# THE TOWNHOMES AT BRADLEY CROSSROADS

LOT 1A, BRADLEY CROSSROADS FILING NO. 1B, SECTION 2, TOWNSHIP 15 SOUTH, RANGE 66 WEST of the 6th PRINCIPAL MERIDIAN, EL PASO COUNTY, COLORADO

DRAWN BY: TJW  
 CHECKED BY: RDH  
 JOB NO: 170620  
 DATE: 23 JANUARY 2019  
 DRAWING NO: -TOWNHOME  
 SHEET: 1 of 2

THE TOWNHOMES AT BRADLEY CROSSROADS

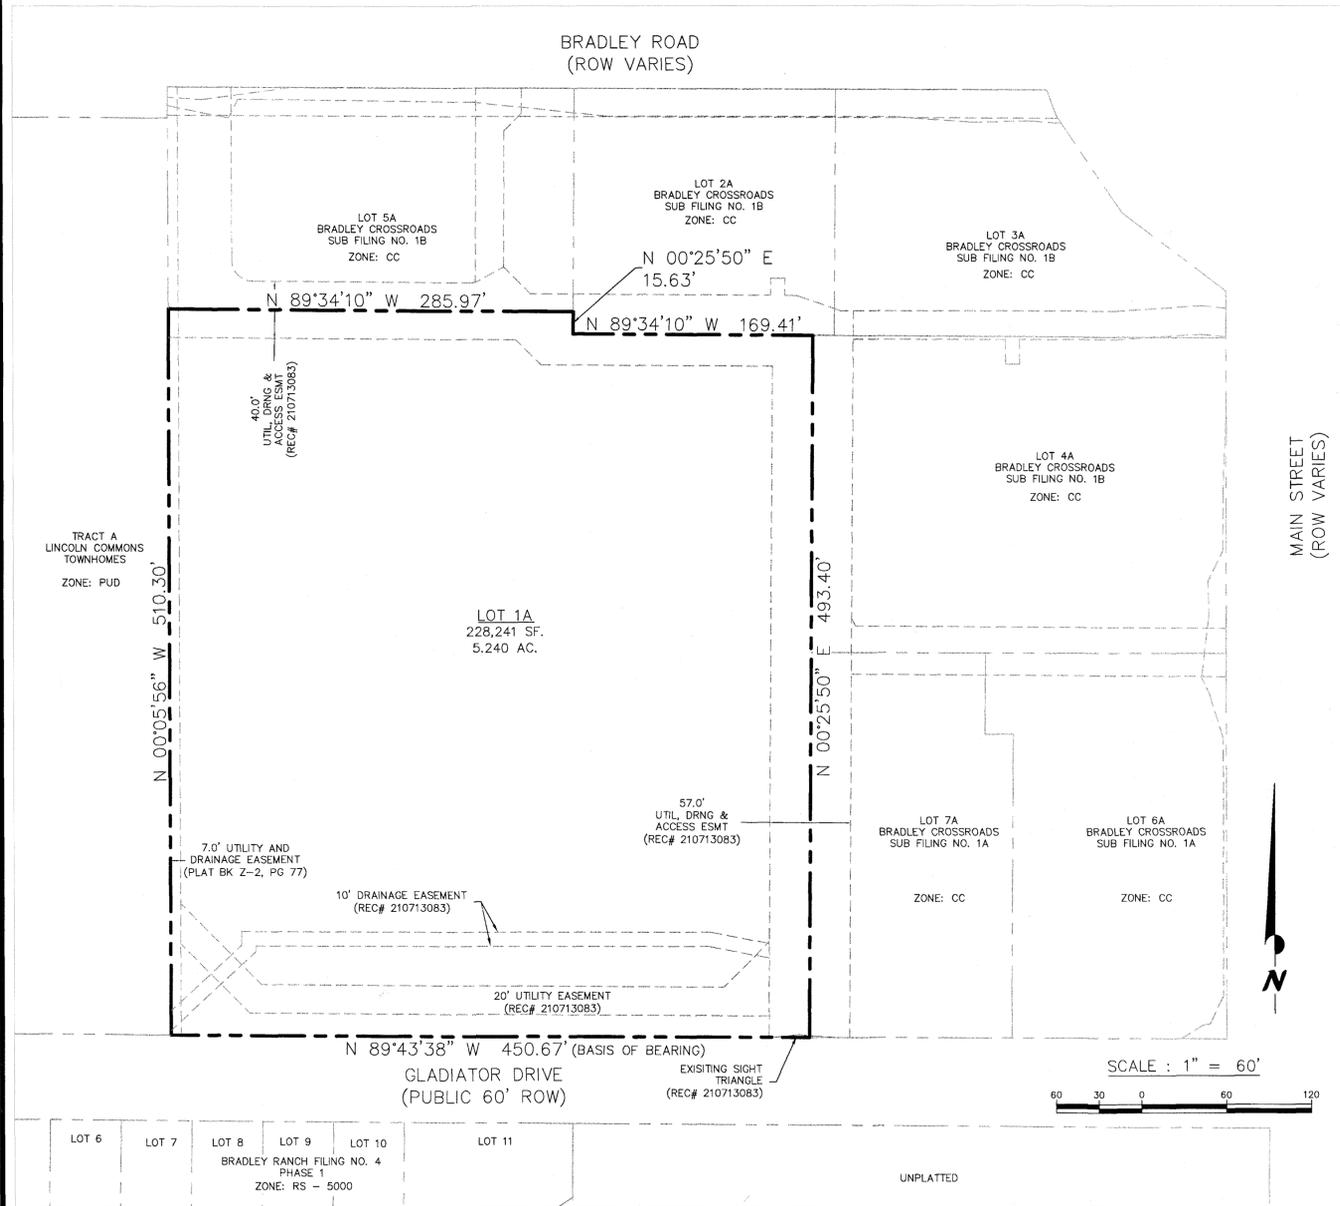
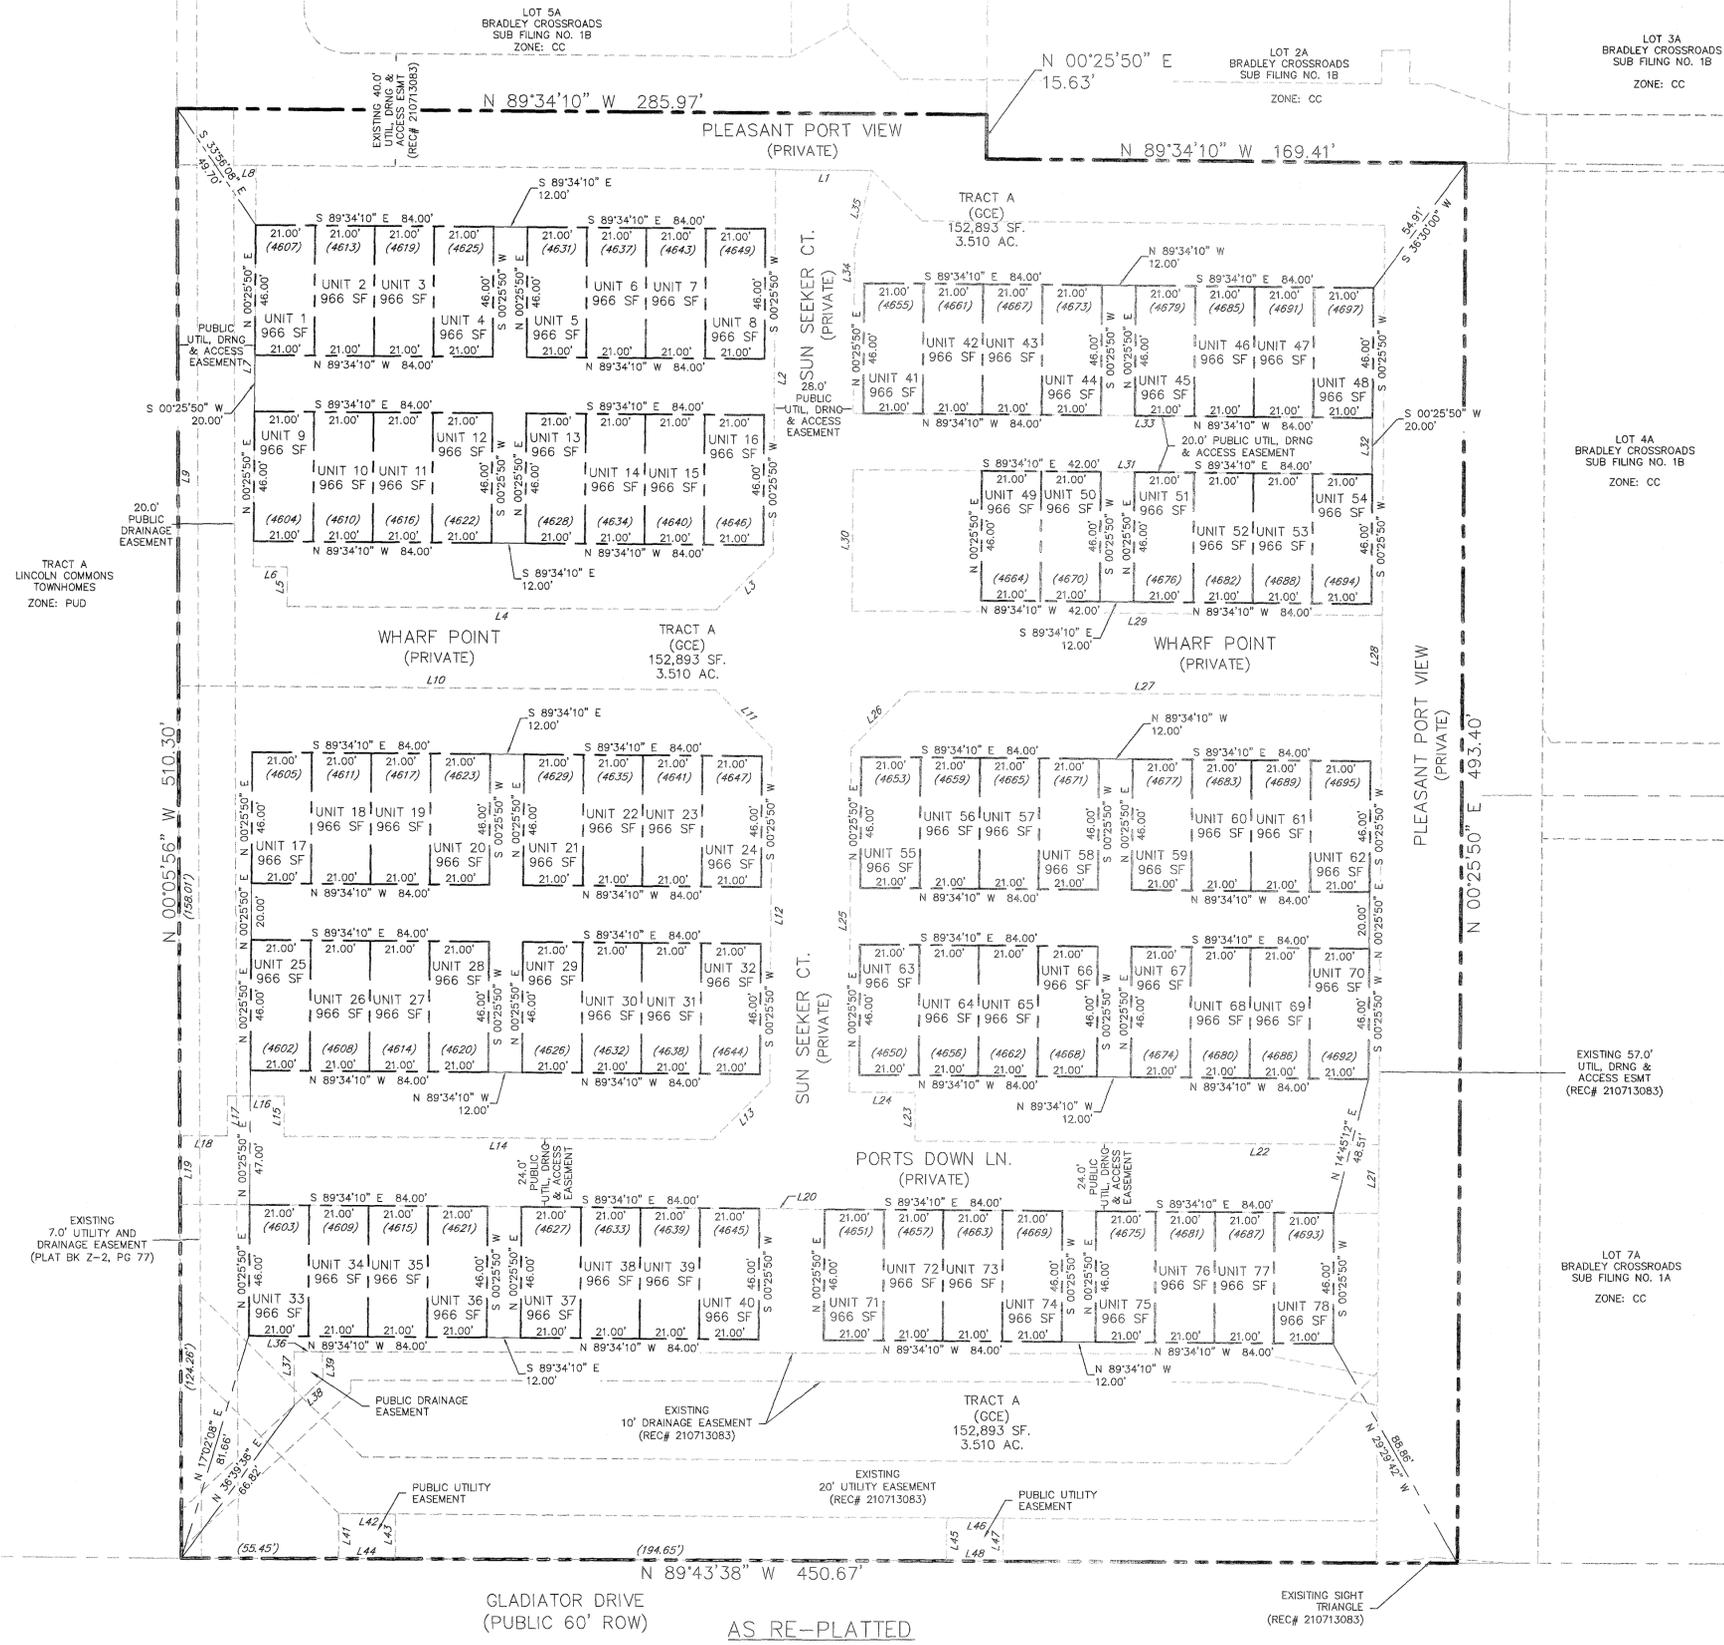
same comment-add UNIT they are not buying property but a structure

Update the FEMA FIRM # and date to the December 2018 date.

Delete words "Board of"
